2022/0608

Description: Variation of conditions 2, 6, 20 and 22 of application 2019/0089 (Demolition of existing bungalow and the development of 235 no. dwellings with formation of new access, car parking, landscaping and public open space) to allow for a number of minor amendments to layout, housetypes, boundary treatments, garages and materials.

Site Address: 58 Lundhill Road, Wombwell, Barnsley, S73 0RJ.

Drawing Title
SG1 Garage
Single Detached Garage
6m x 3m Internal Garage
Plans, Section & Elevations

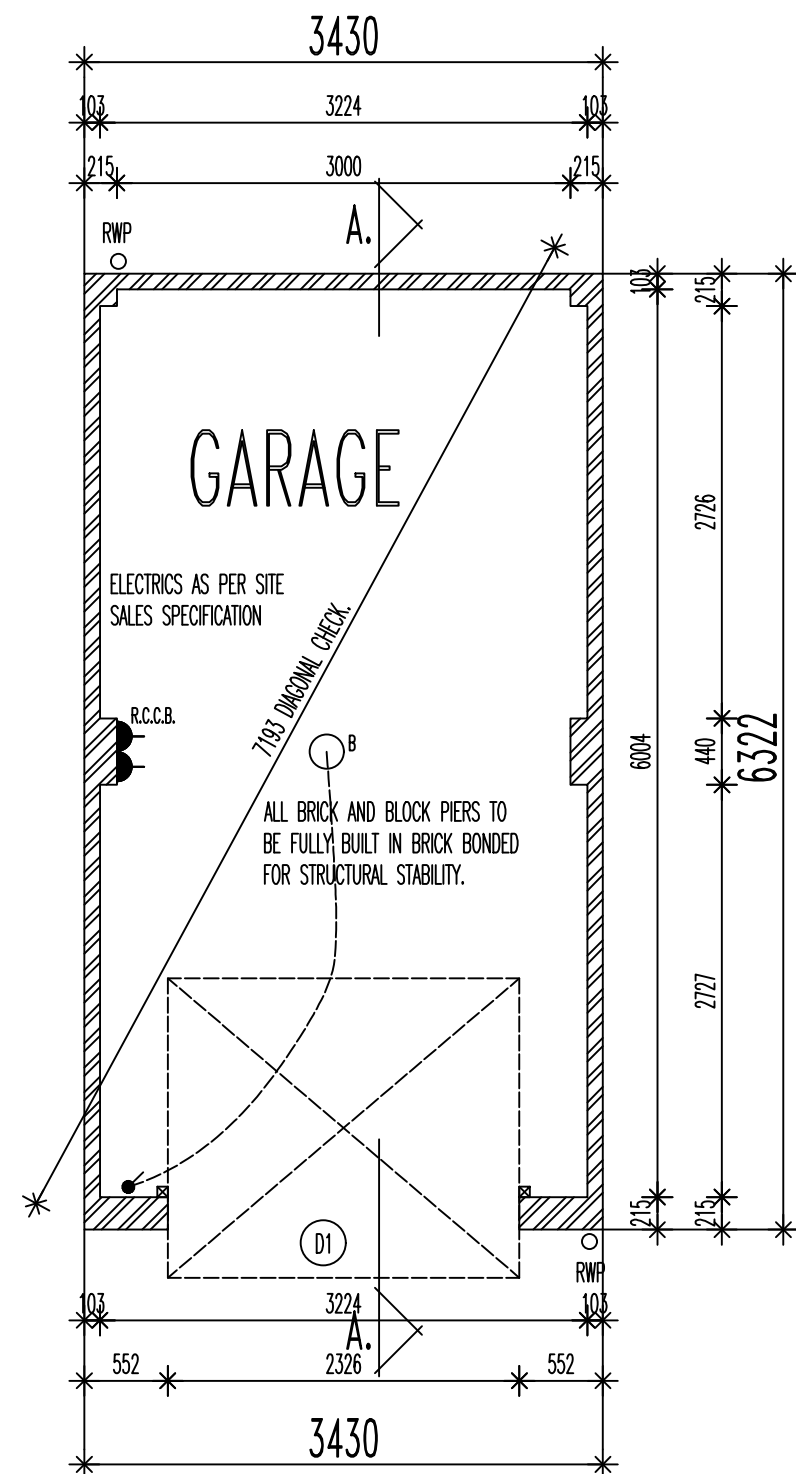
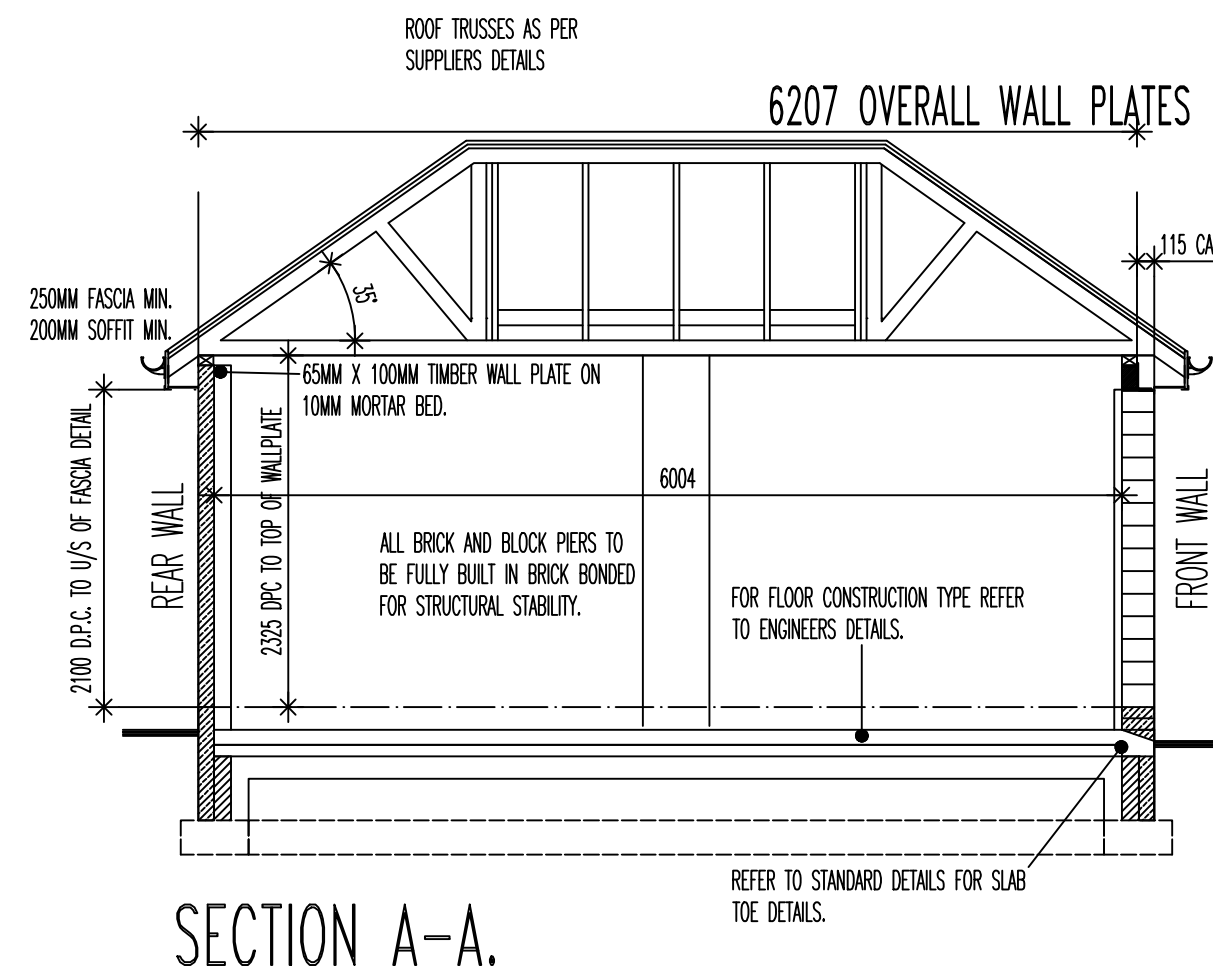
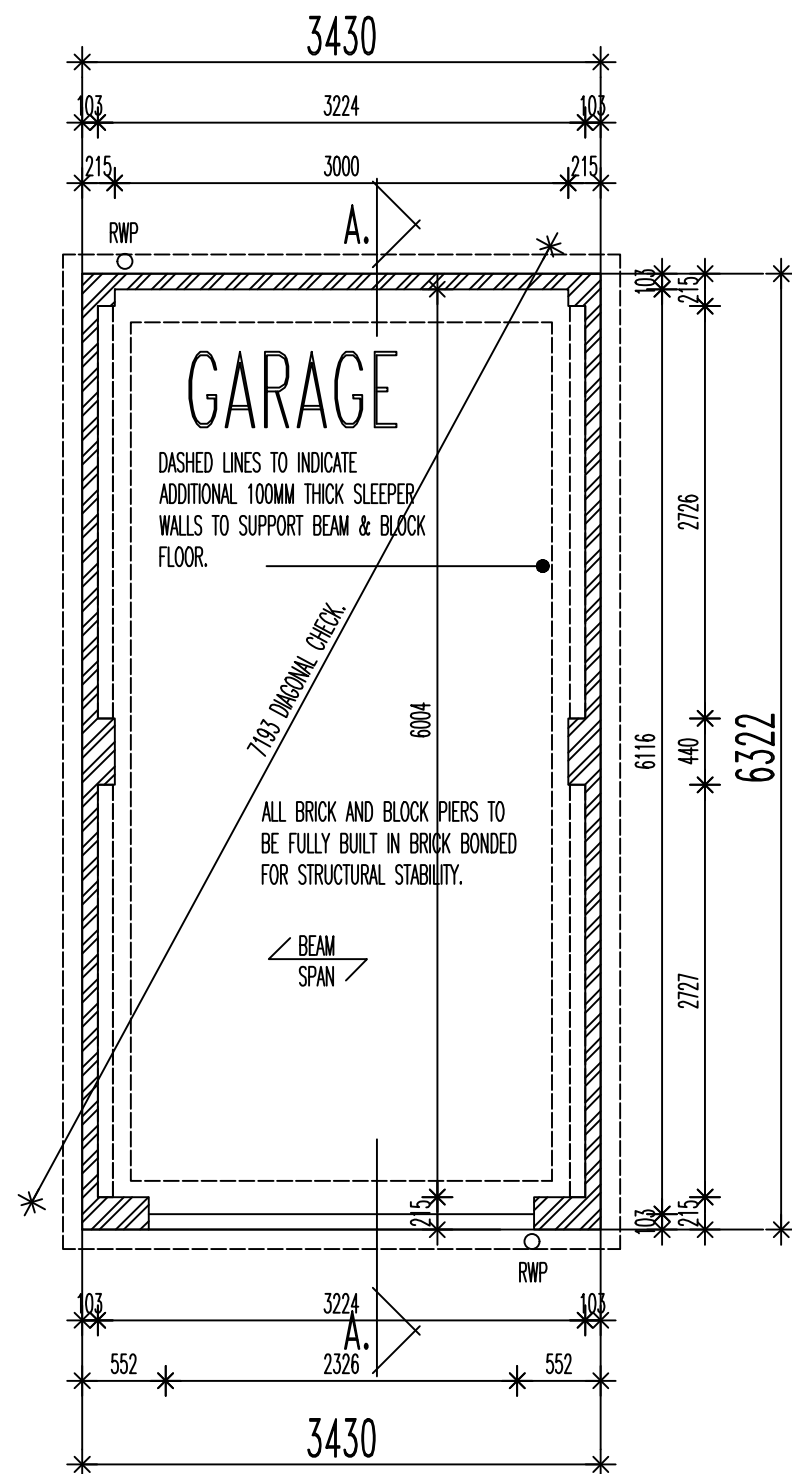
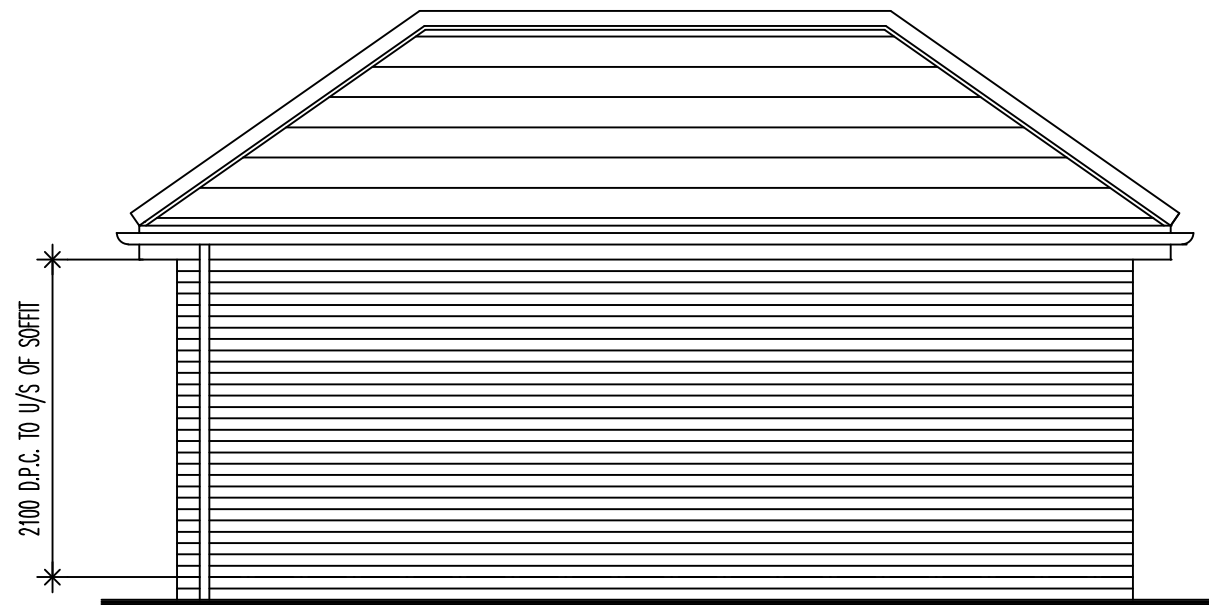
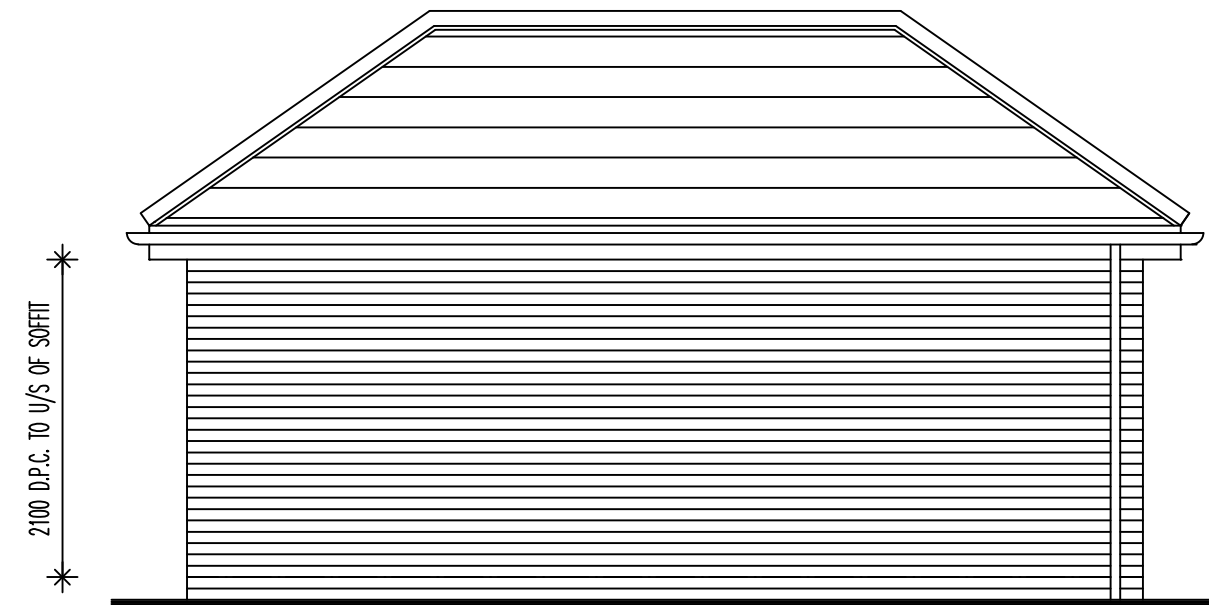
In regard to this application, amendments were sought to ensure that driveways were positioned appropriately and were not in close proximity to ramps or traffic calming features and amended garage plans were provided to ensure they all meet the minimum dimensions of 3m x 6m. The amendments were deemed acceptable and as such highways support the variation of condition 2. Further, highways have reviewed the layout plan, which shows bicycle storage facilities within the curtilage of each property, and as such they are satisfied that the wording of the condition can now be compliance only.

Drawing Title
Materials Layout

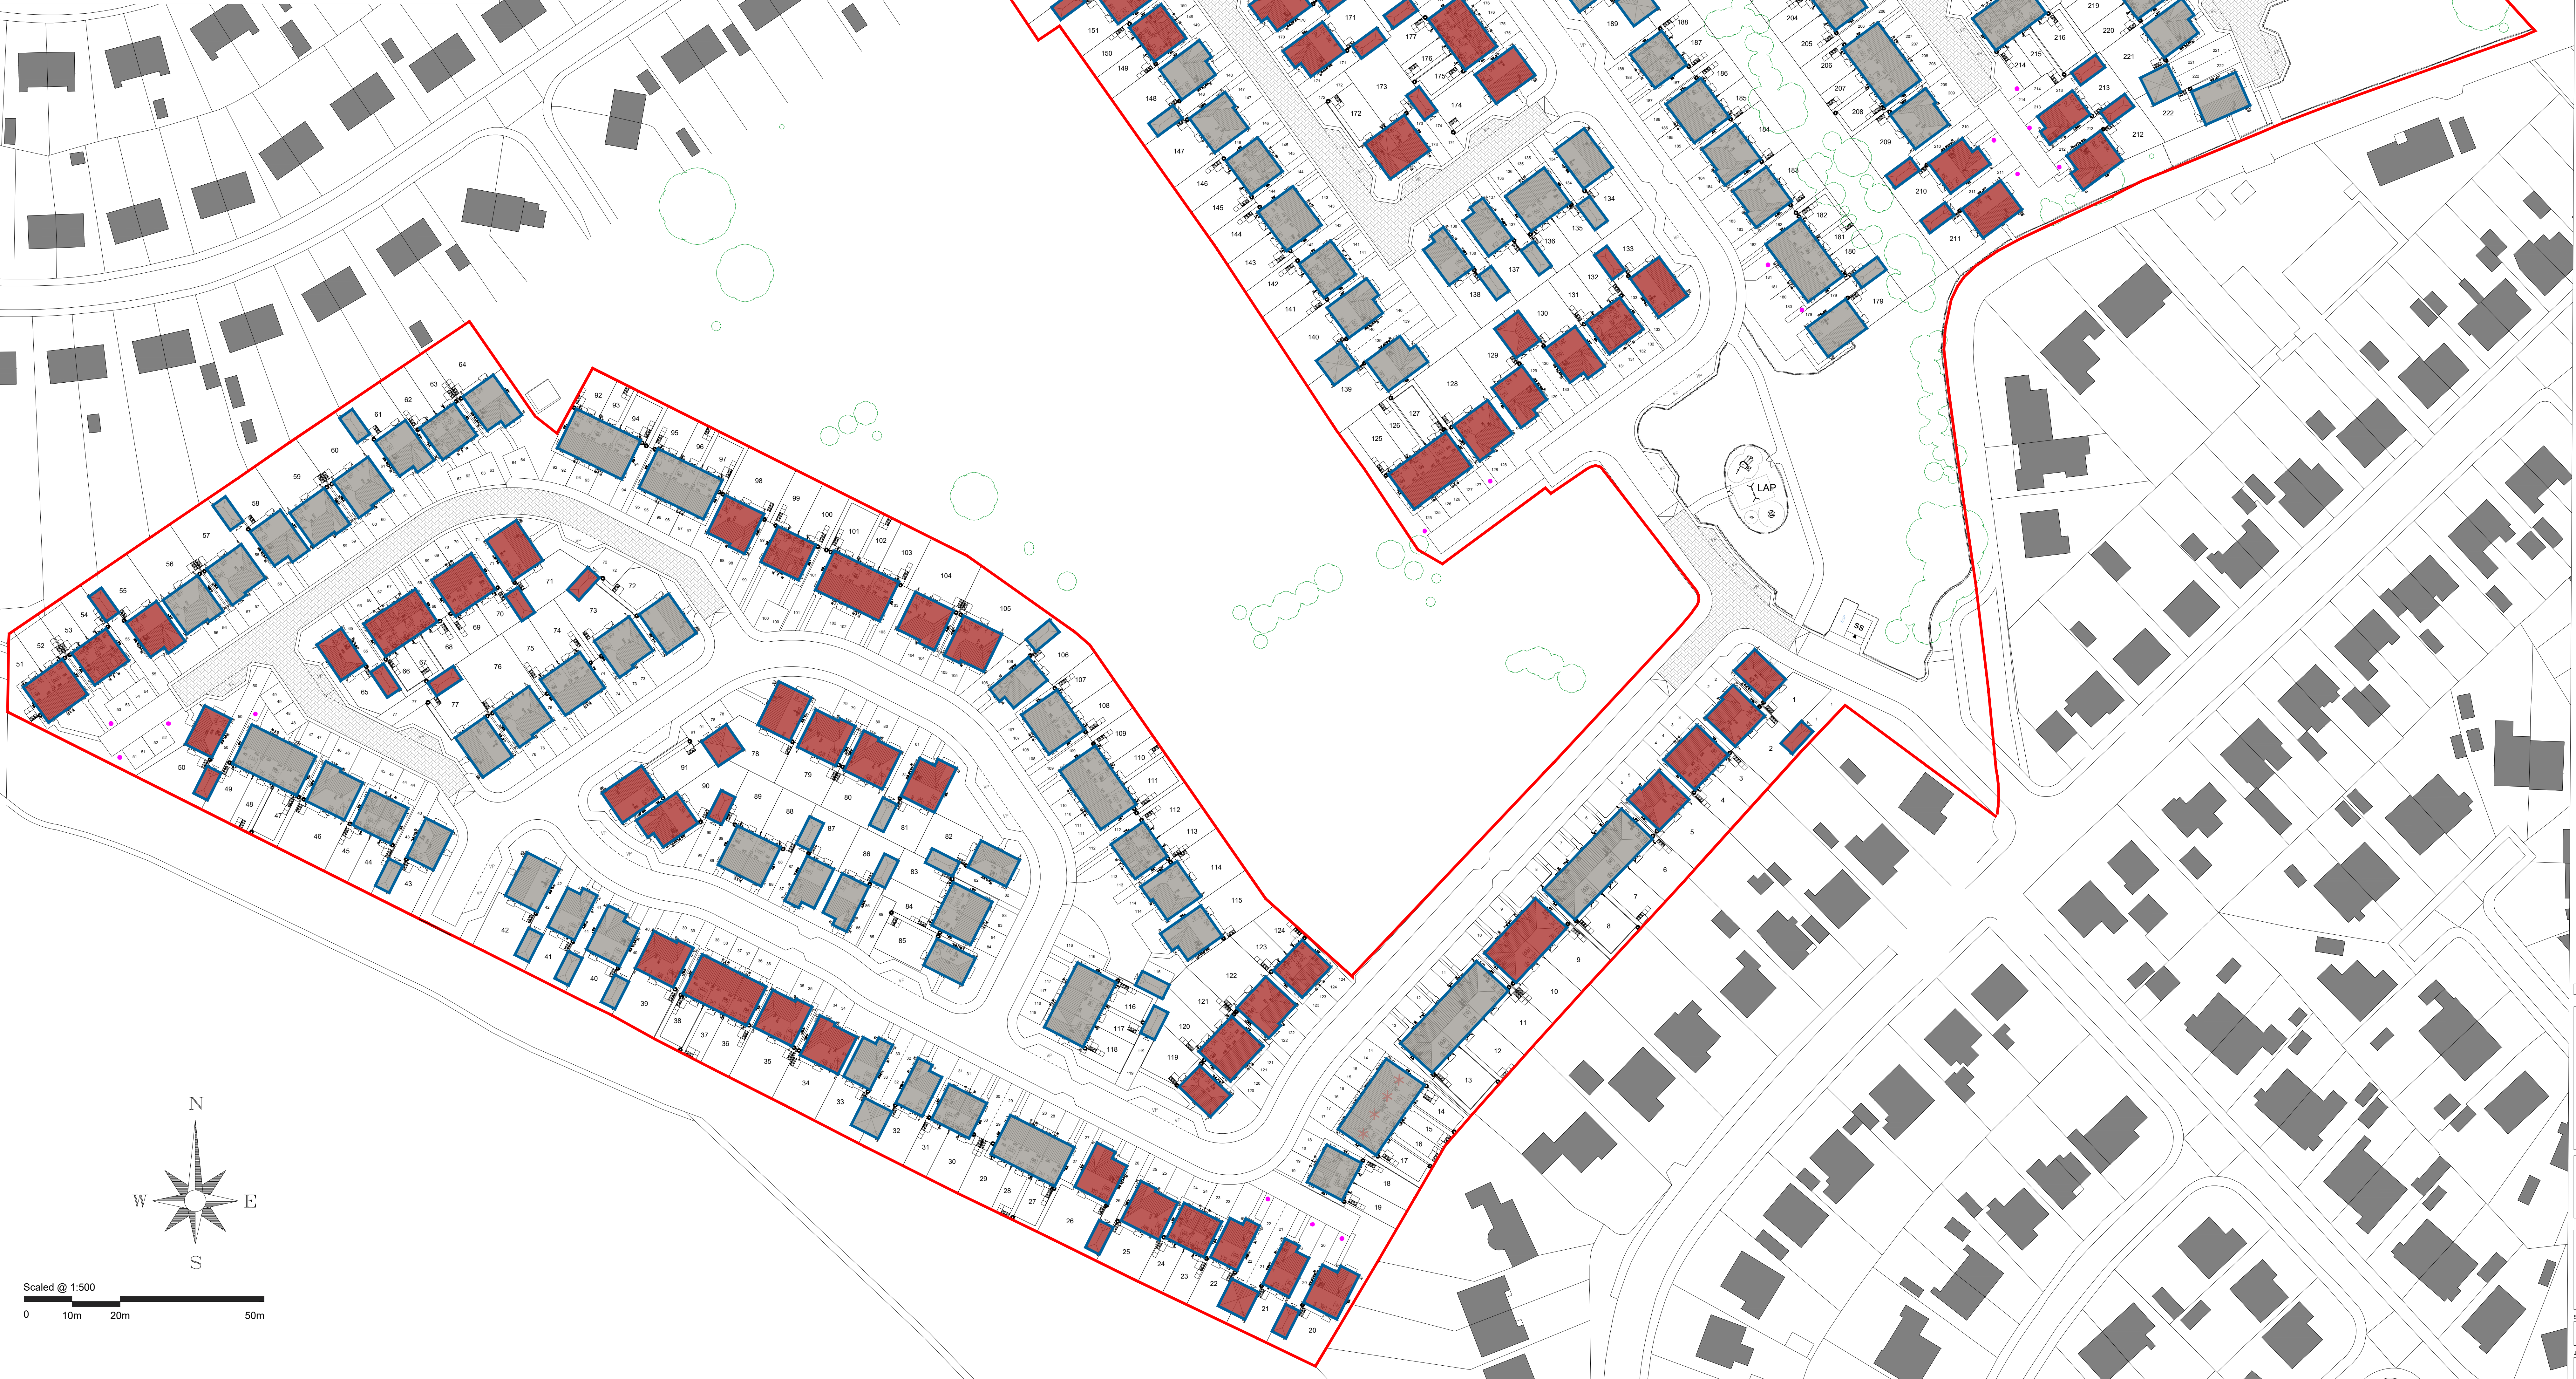
The applicant has provided an amended material layout which proposes a mix of slate grey and terracotta concrete tiles and stone walls. The originally approved scheme included 3 different facing materials (buff brick, red brick, and stone) to provide interest and visual breaks. The lack of facing materials would not create visual interest and it is therefore considered that notwithstanding the material layout submitted, a materials condition is requesting the submission of materials is necessary to ensure the development will be high quality and sit well within the existing area. An amended boundary treatment layout plan has been provided which includes railings to greenspaces and fences to residential properties and is considered to be acceptable.
